167 Fore Street – Ocean Gateway Garage Addition

April 23, 2019

Amendment

Level II Site Plan Application

Title
SITE PLAN

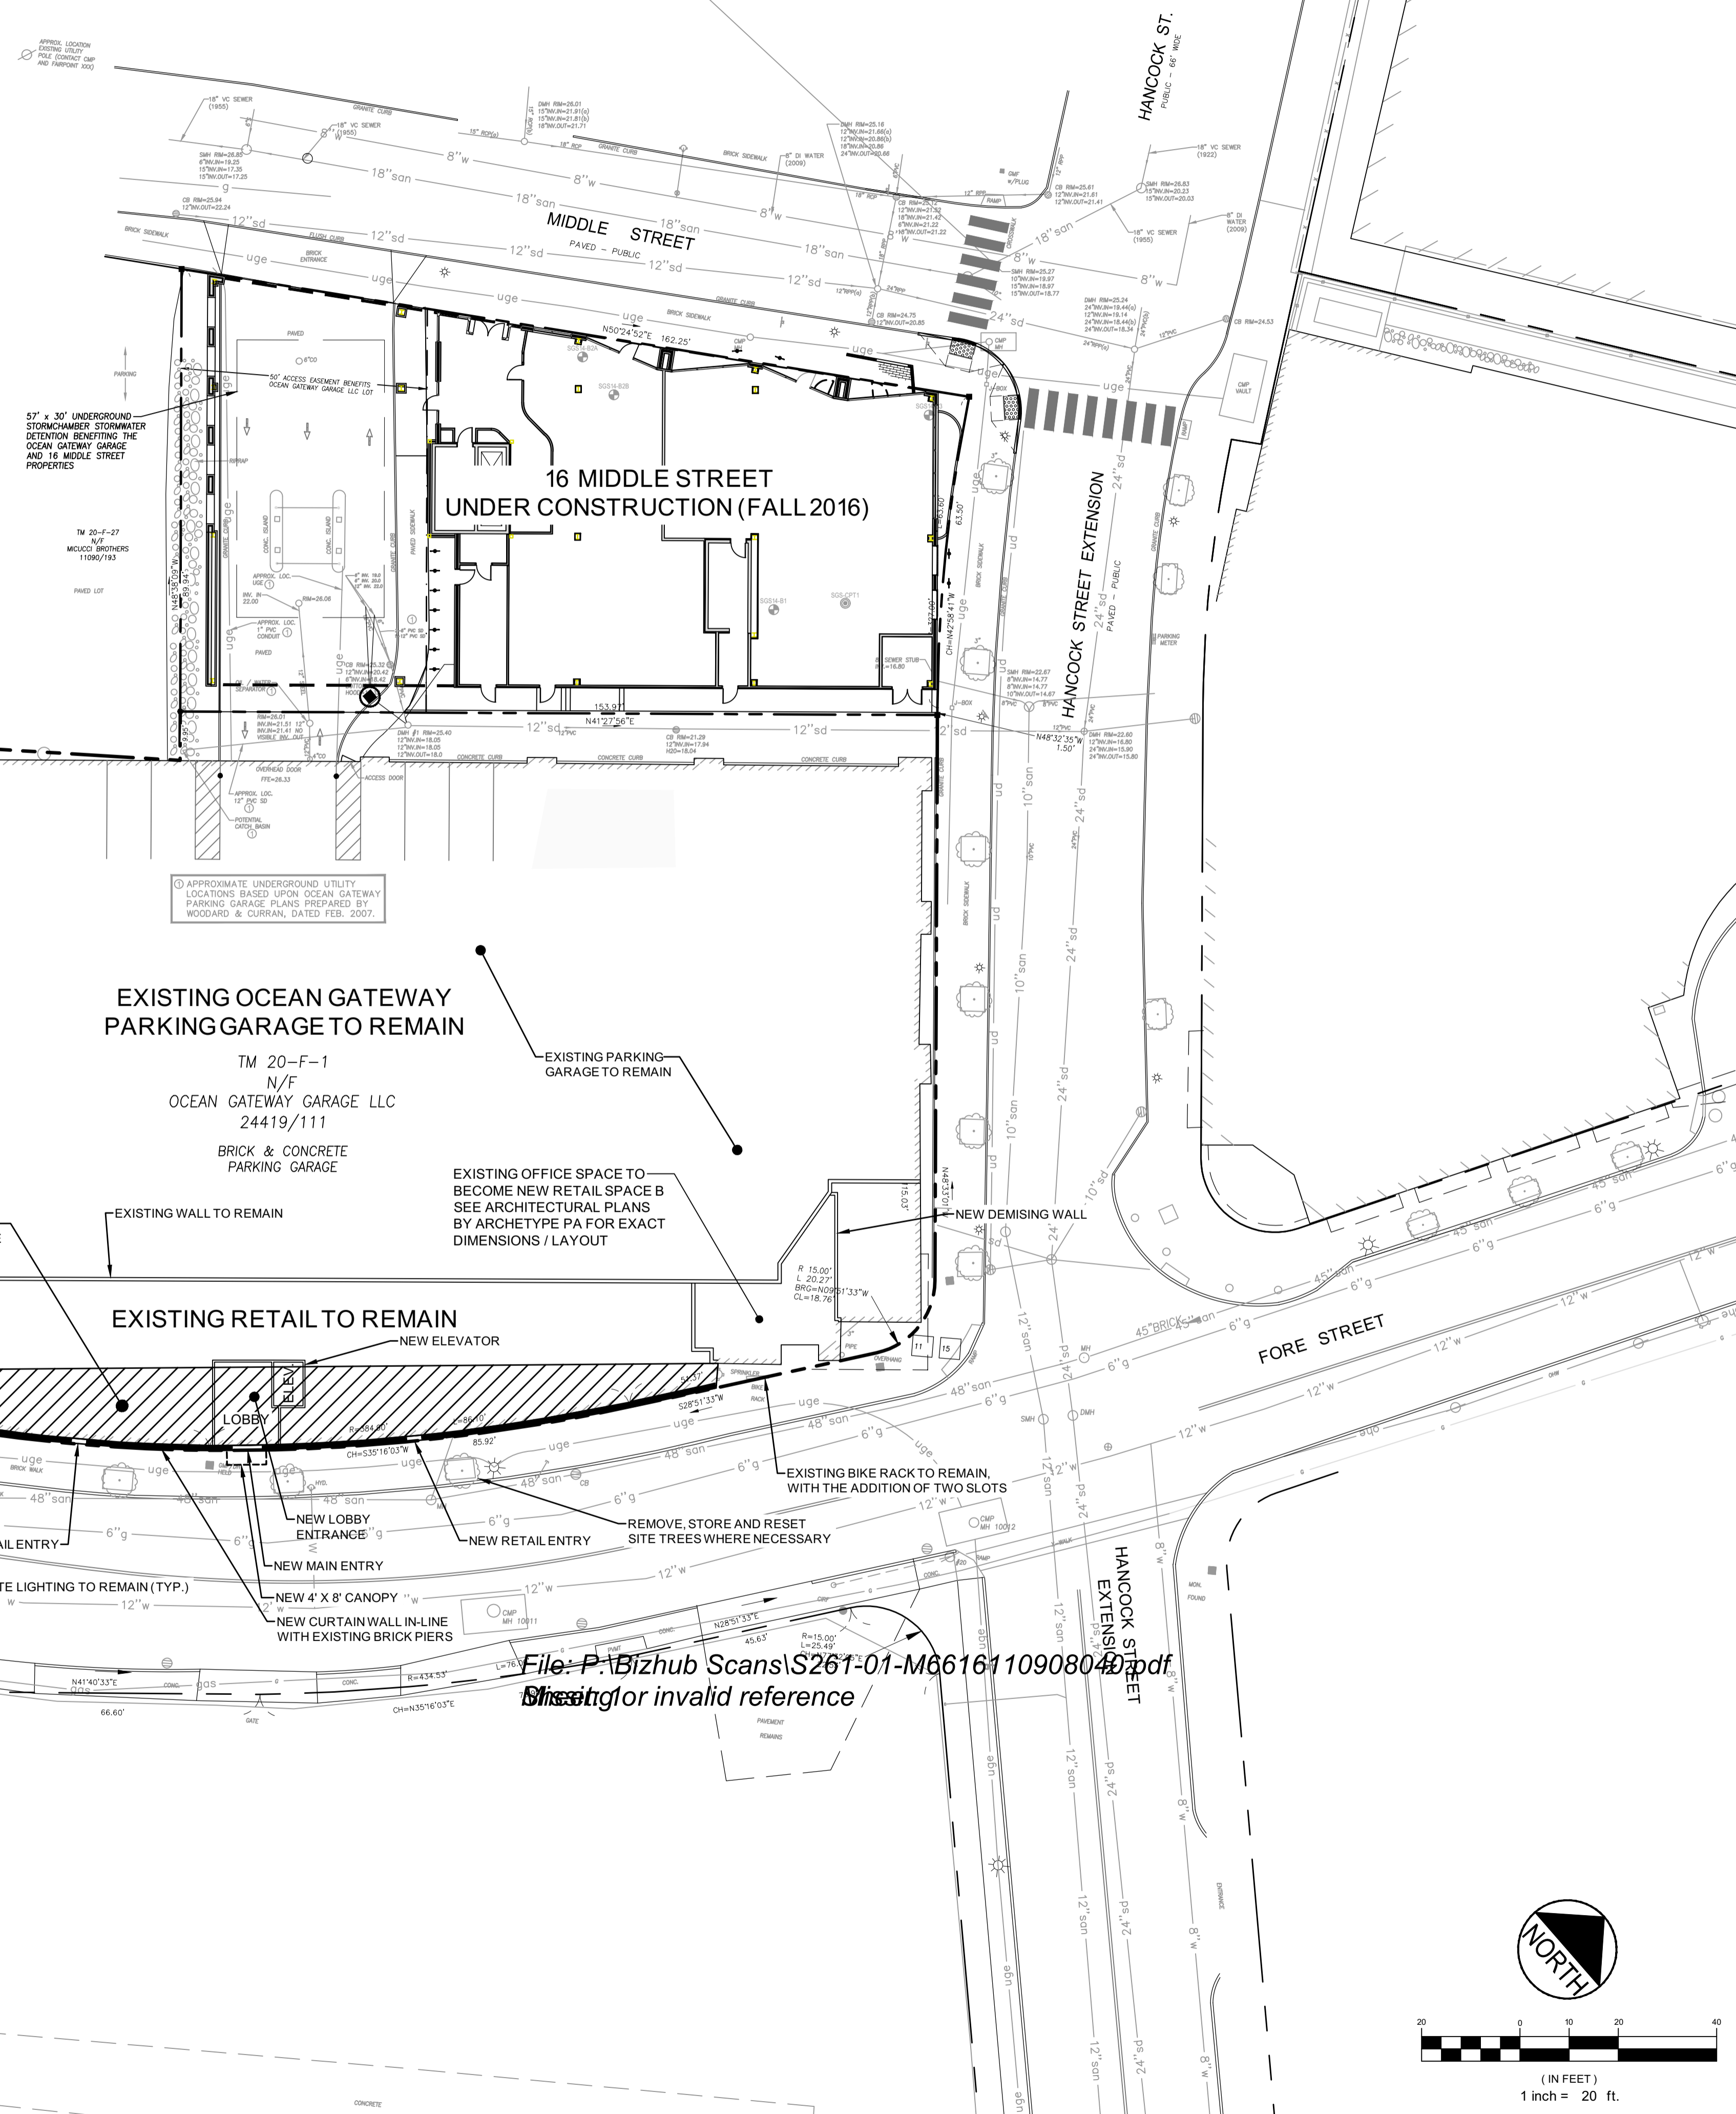
The attached plans (revised site plan and mechanical plans) demonstrate the amendment to the HVAC design as part of the original Level II Site Plan application for the Ocean Gateway Garage Addition at 167 Fore Street.
